# KITTITAS COUNTY COMMUNITY DEVELOPMENT SERVICES

RE: *Valley Vet CUP (CU-13-00006)*

# MEMO

AC-14-00073

1 SITE PLAN
 SCALE: 1" = 20.0'

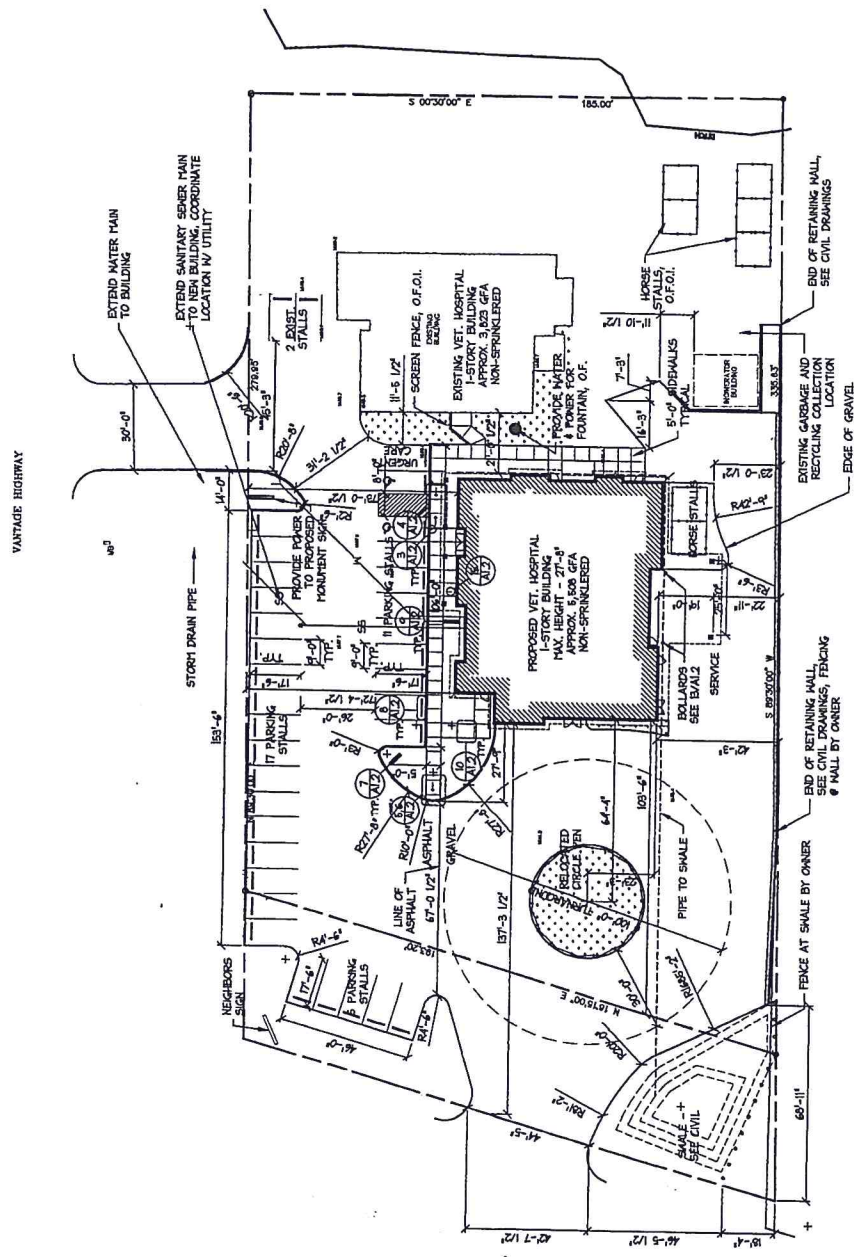
Kittitas County Community Development Services received two packets of information from you on October 13, 2014 and November 12, 2014 respectively. Staff has reviewed this information which illustrates proof of meeting the majority of the conditions of the Valley Vet Conditional Use Permit (CU-13-00006) to operate a veterinary clinic. The one outstanding condition that has not been fully met is item 8.1.1 on page 9 of Resolution 2014-005. Public Works performed an inspection of the improved access approach on December 11, 2014 where they determined the access turning radius did not meet the approved design of 30 feet (please see the attached memo from Public Works).

Kelly Bacon and Doug D'Hondt performed an inspection of the improved access approach to map # 17-19-06020-0002. The inspection showed that the turning radius did not meet the approved design turning radius of 30 feet. Kittitas County Public Work is willing to allow a temporary Occupancy Permit under the following requirements:

- 1) Owner is to place a layer of gravel and compact the surface on the sides of the existing access as built. Once this is complete please contact Public Works for an inspection. Once approved, Public Works will sign off on the Temporary Certificate of Occupancy.
- 2) Applicant will have until June 30, 2015 to complete the work needed on the turning radius and contact Public Works for inspection.
